From: Liz Rogers [REDACTED]
Sent: 08 November 2017 10:40
To: Planning.Responses
Subject: RE: Planning Consultation on: AL/115/17/OUT

App No: AL/115/17/OUT

Address: Wings Nursery Lidsey Road Aldingbourne PO20 3SU

Proposal: Outline application with some matters reserved for the erection of 55 No. dwellings, sustainable drainage measures, public open space, children's play area, landscaping & all other associated works. This application is a Departure from the Development Plan

Photograph 30: Tree 1 Oak trunk and canopy

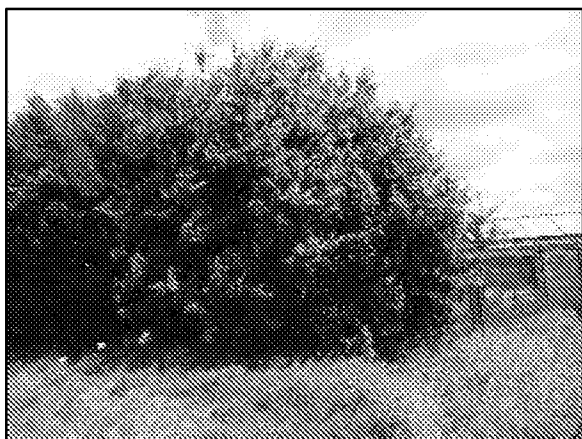
Within the preliminary ecological appraisal three English oak trees were identified as having bat roosting potential and would be affected by the proposed works. It appears that no further survey work has been undertaken on these trees so we are unable to establish if bats are roosting within them. Unless these trees are being retained and undisturbed further emergence surveys will be required on these trees. These surveys and any mitigation that may be required will need to be submitted as part of the application prior to determination.

Figure 6.1: Mitigation strategy

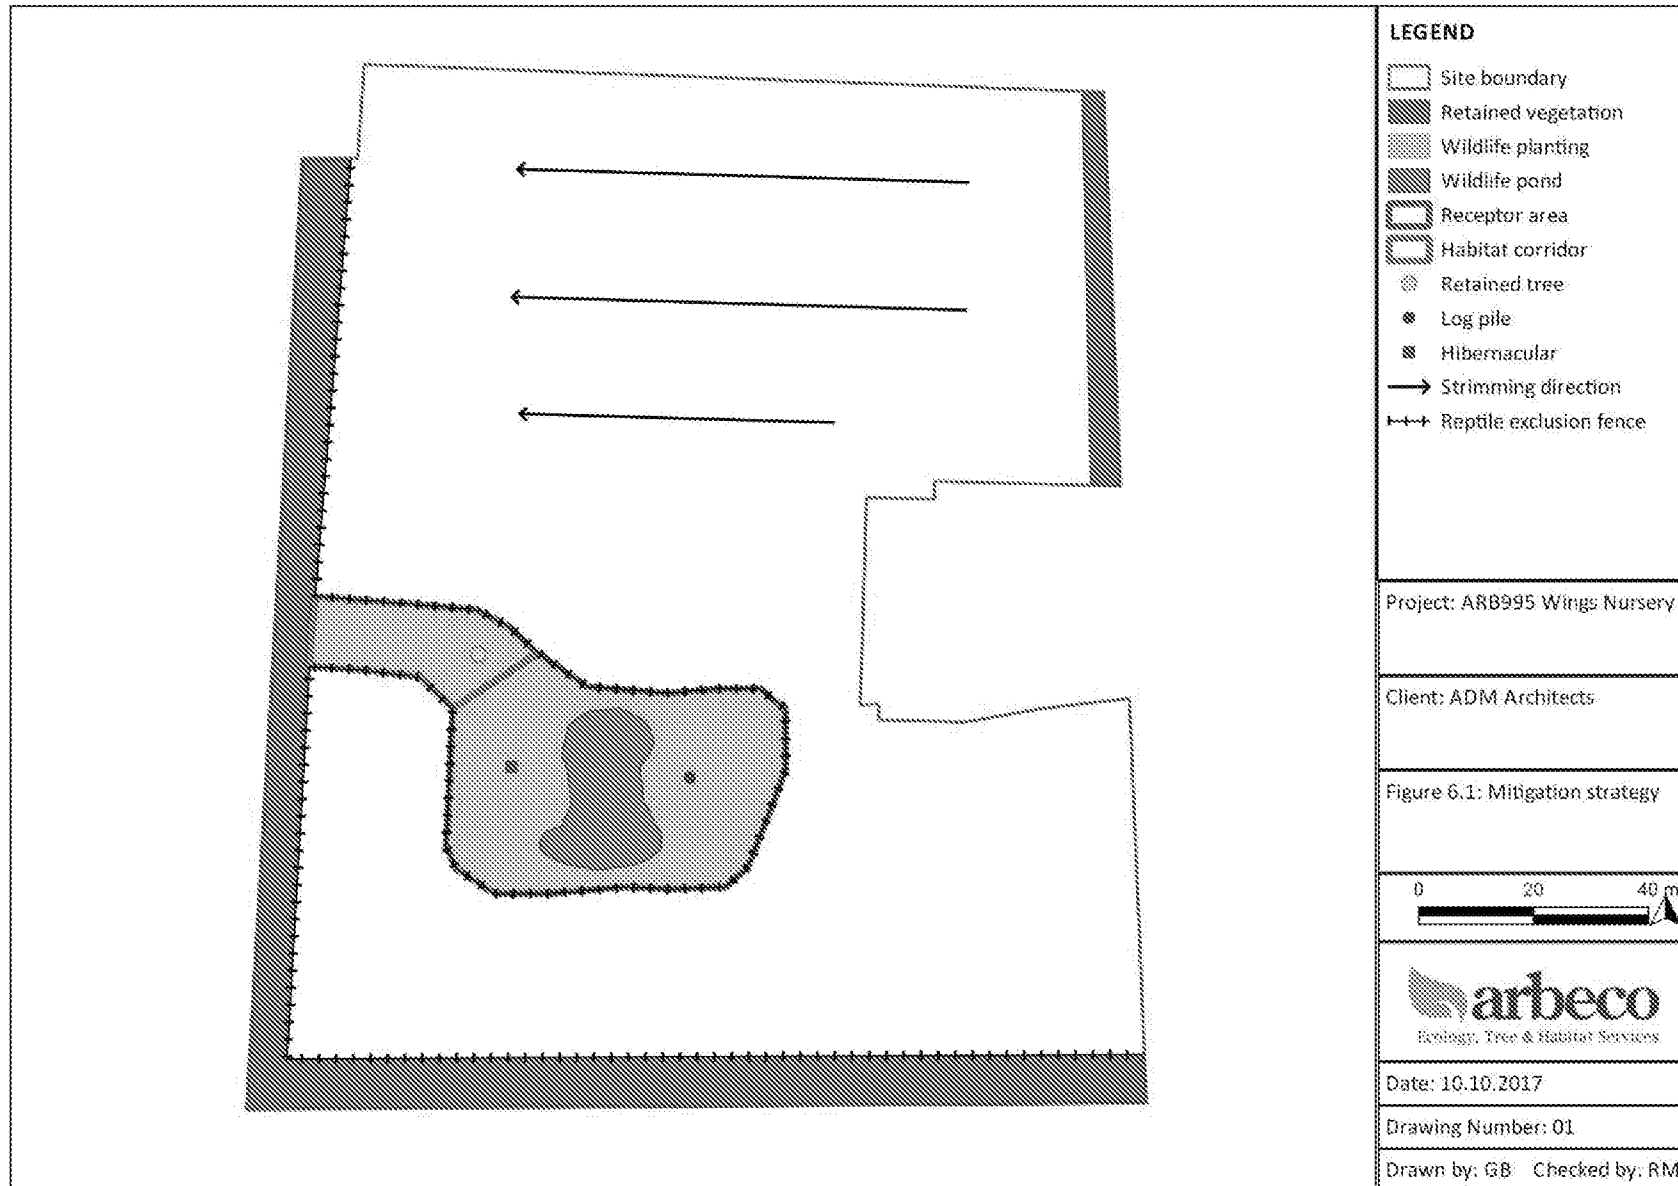
The reptile survey has shown that there is a small population of reptile's onsite. Due to this mitigation has been proposed within the Reptile Survey Report (October 2017) and we are happy that the proposed mitigation is suitable and this can be conditioned. The applicant should note that no construction works can commence until the reptile translocation has taken place.
